Consultation Response from KC Highways		
2019/92379 adj High Beeches, 585, Manchester Road, Linthwaite, Huddersfield, HD7 5QX		
Erection of detached dwelling		
Date Responded: 11-09-19	Responding Officer: CNB	Responding Ref: K2-2/14
This application is for the erection of a detached dwelling with parking and access improvements within the garden of an existing dwelling. The access is on to A62 Manchester Road, a 30mph two way single carriageway primary distributor road of approximately 9m width with footways on both sides and street lighting present. There are parking bay markings approximately 45m either side of the access and a bus stop 20m to the right of the access. There is one recorded injury accident collision within the area however the proposals will not be expected to exacerbate this. The proposal site benefits from conditional outline permission (13/90860 and 16/93564) for a detached dwelling. The access to the site is along a steep curving private driveway that will be shared with the existing High Beeches dwelling and at the junction with A62 Manchester Road the access is shared with four additional dwellings, 601 to 607 Manchester Road and because of this the width of

| Rev | Description                                                                                | Rev. by      | Date     |
|-----|--------------------------------------------------------------------------------------------|--------------|----------|
| D   | Proposed Site layout                                                                       |              |          |

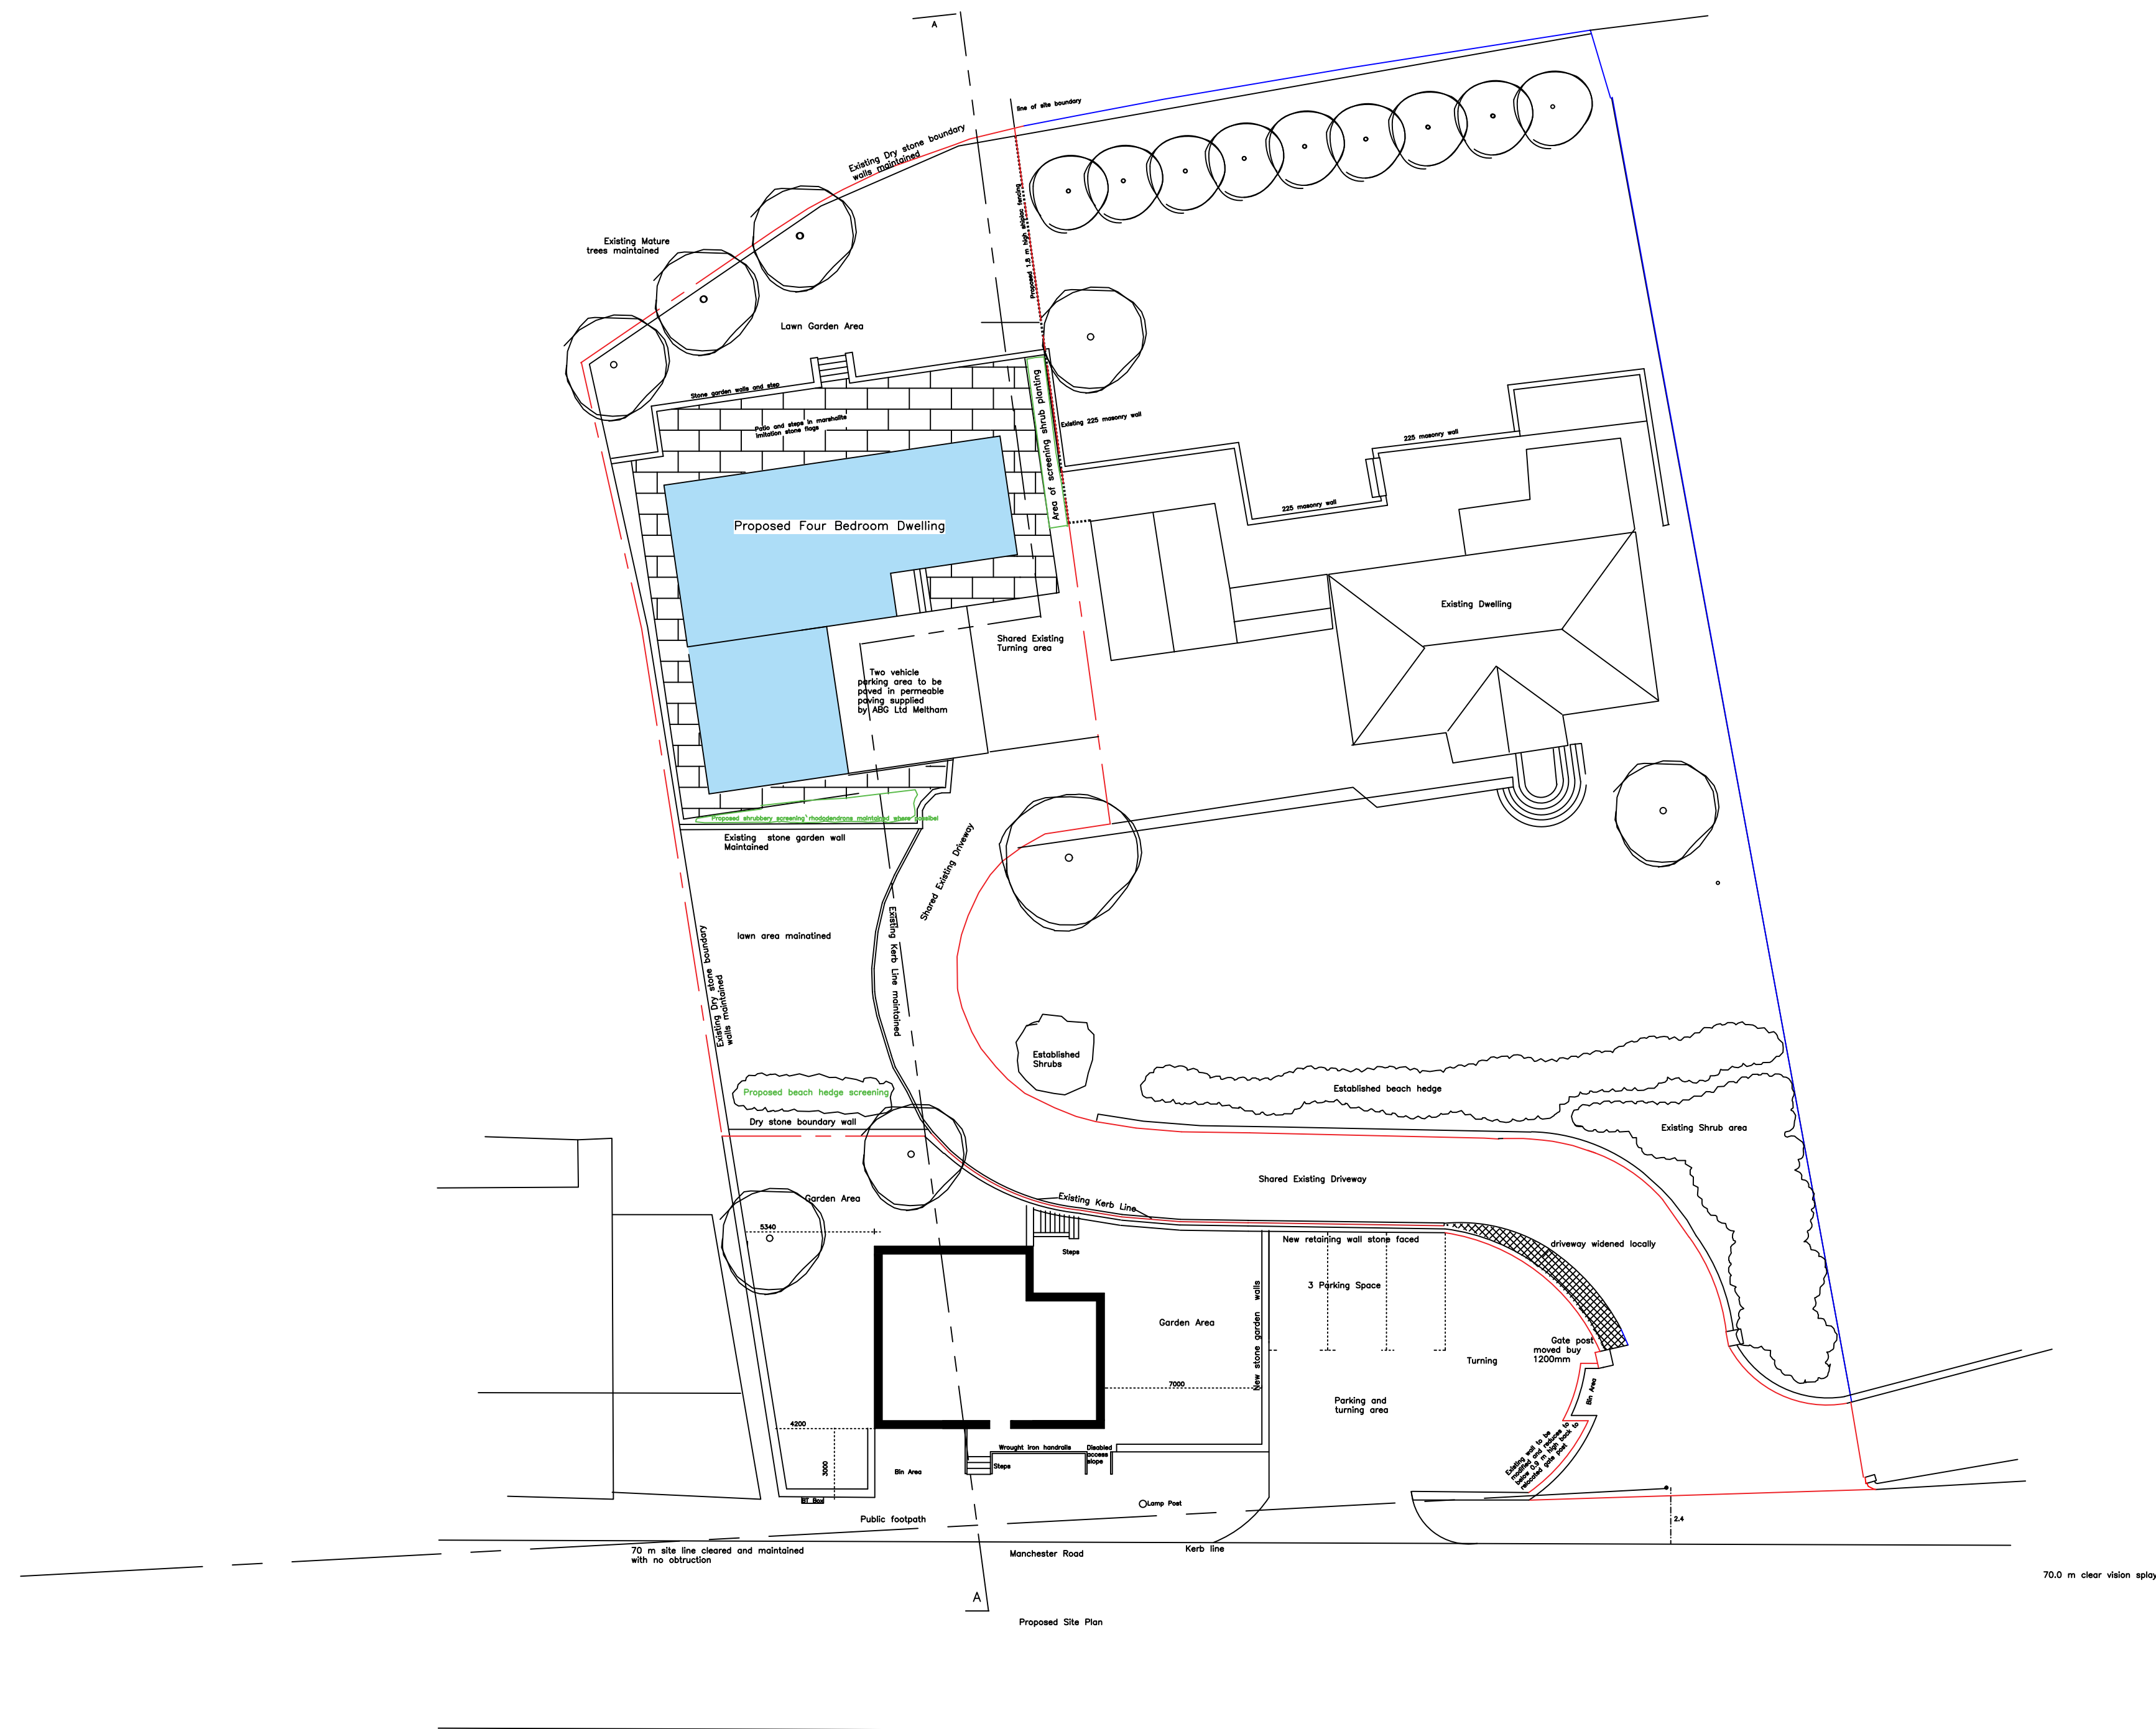
Before the development commences a scheme detailing the location and cross sectional information together with the proposed design and construction details for all new retaining walls adjacent to the existing highway including any modifications to the existing highway retaining wall on the A62 Manchester Road shall be submitted to and approved by the Highway Authority in writing. The approved scheme shall be implemented prior to the commencement of the proposed development and thereafter retained during the life of the development.
